Consultee Comment for planning application 22/01682/F

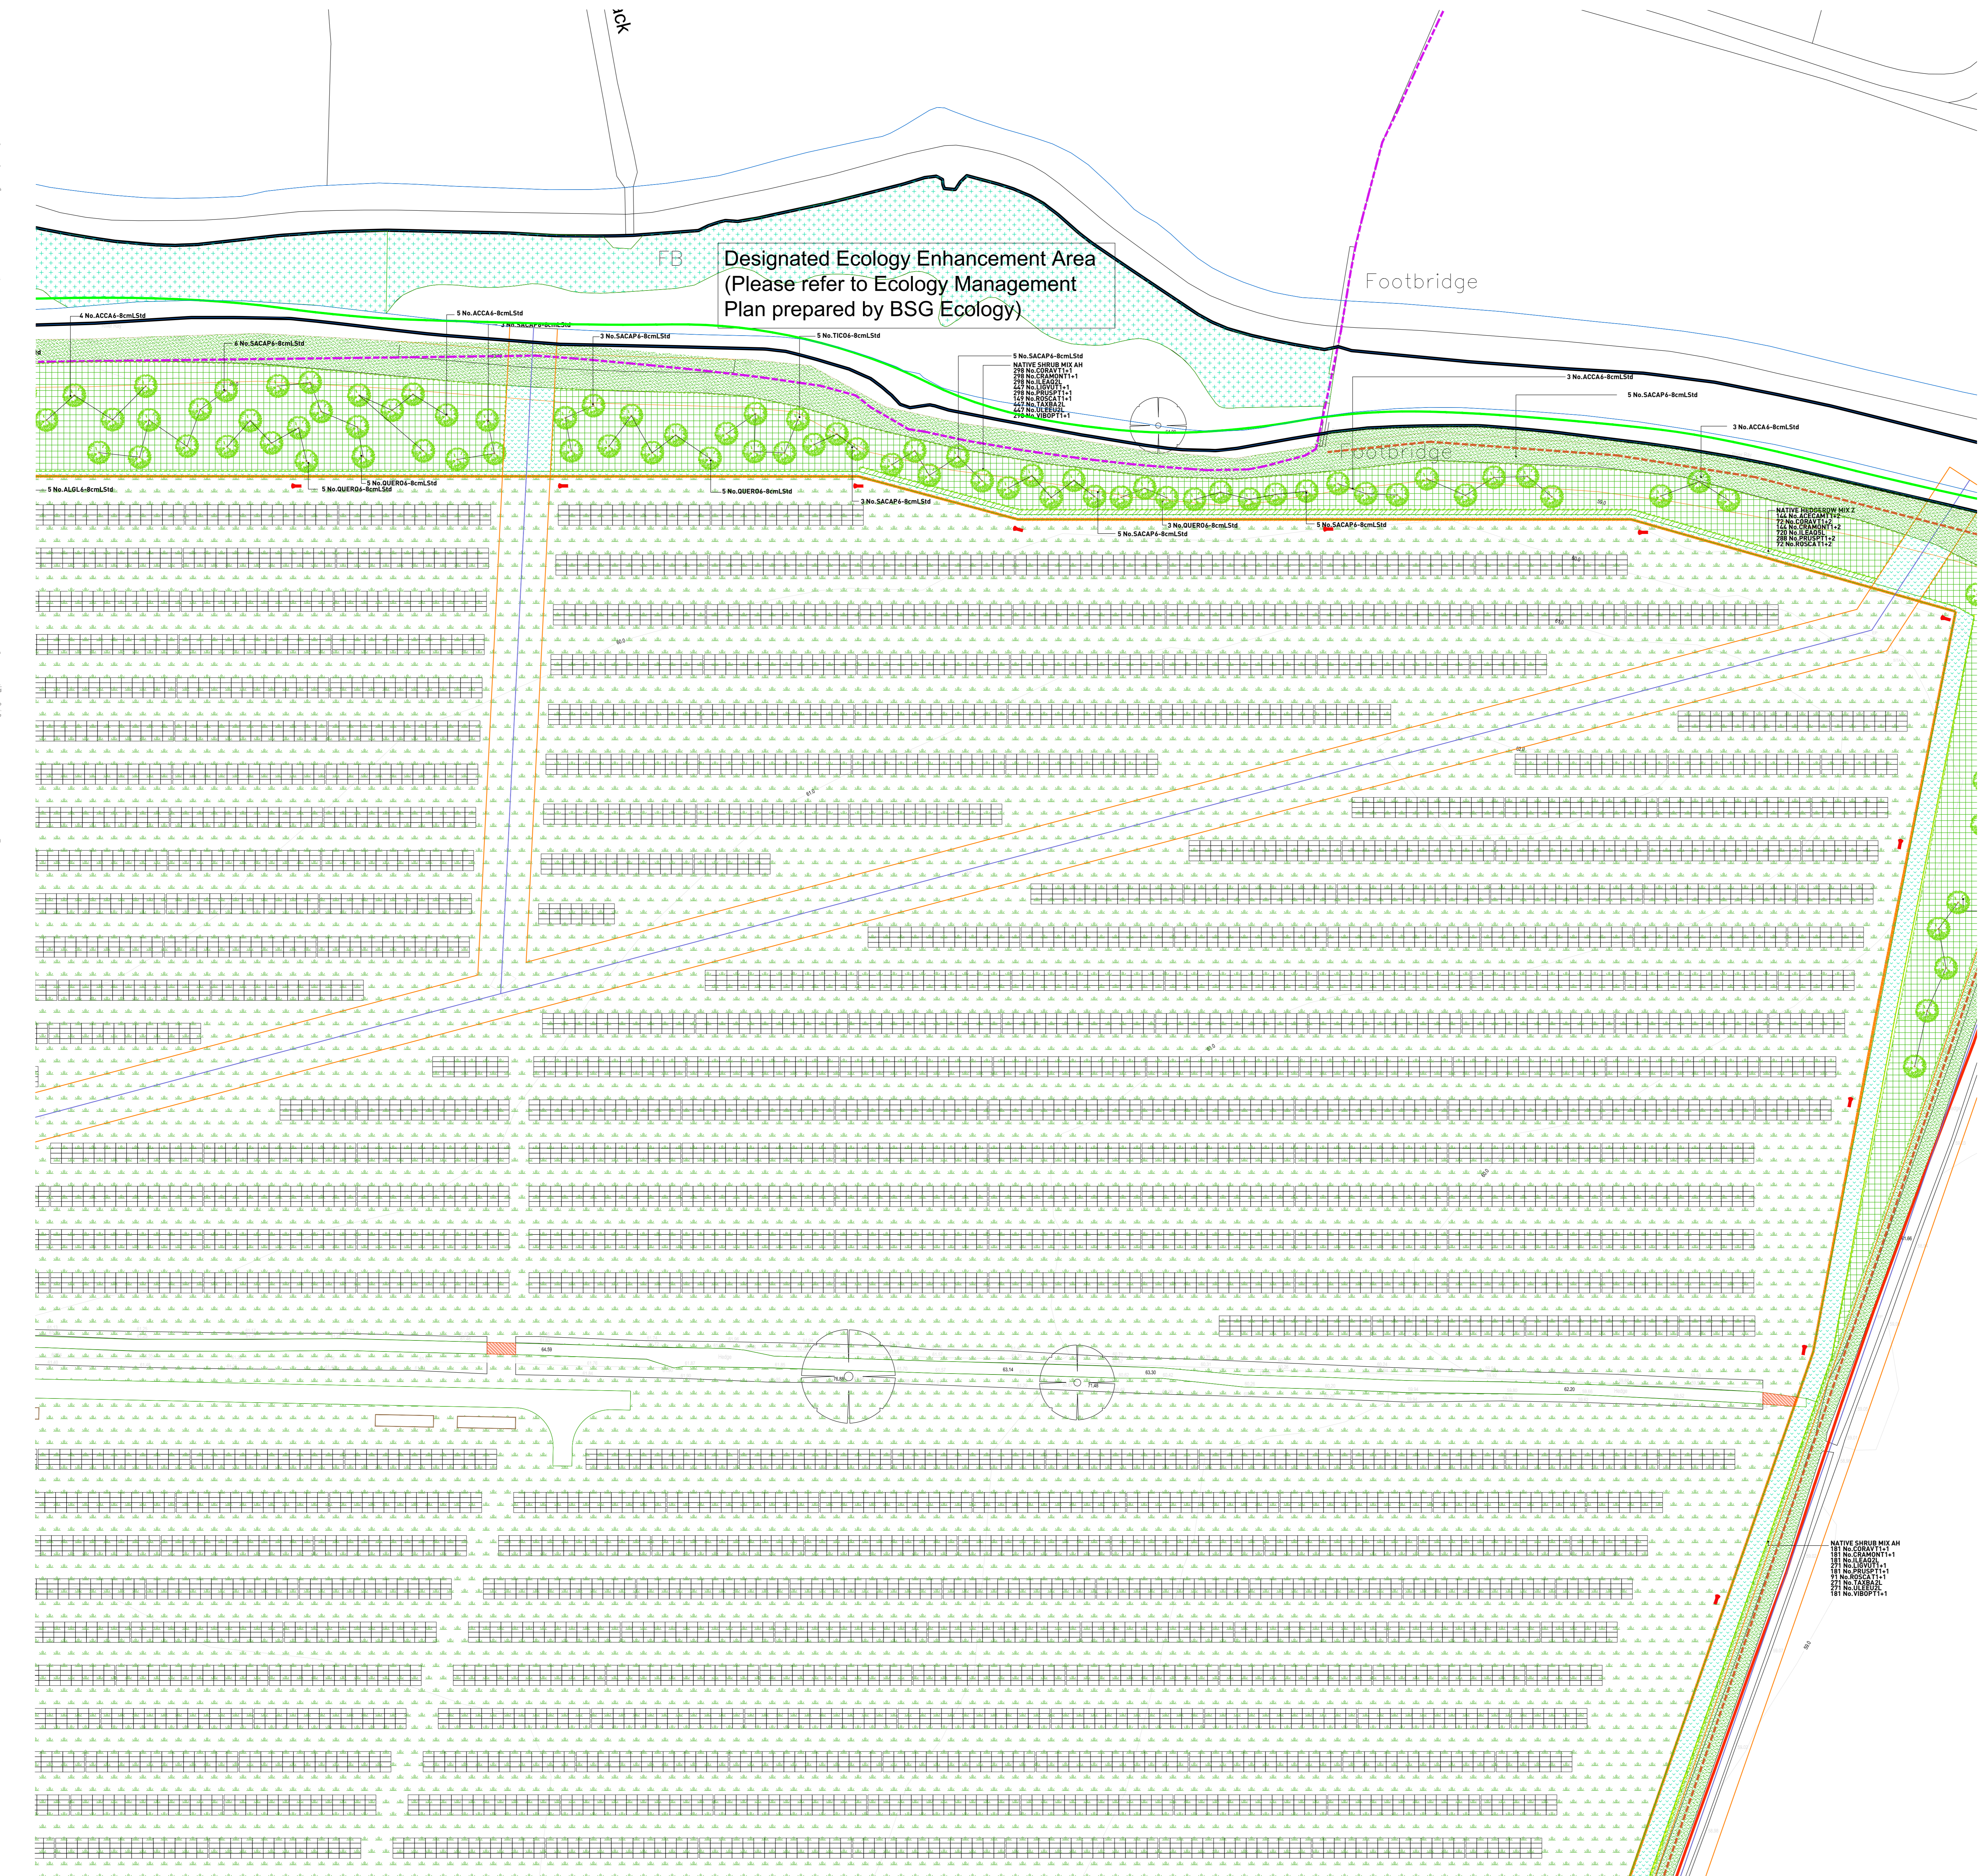
Any fencing proposed should be permeable to wildlife and as minimal as feasible. The 2.1m fence proposed here would be unusual in this landscape and may impact low flying wildfowl.
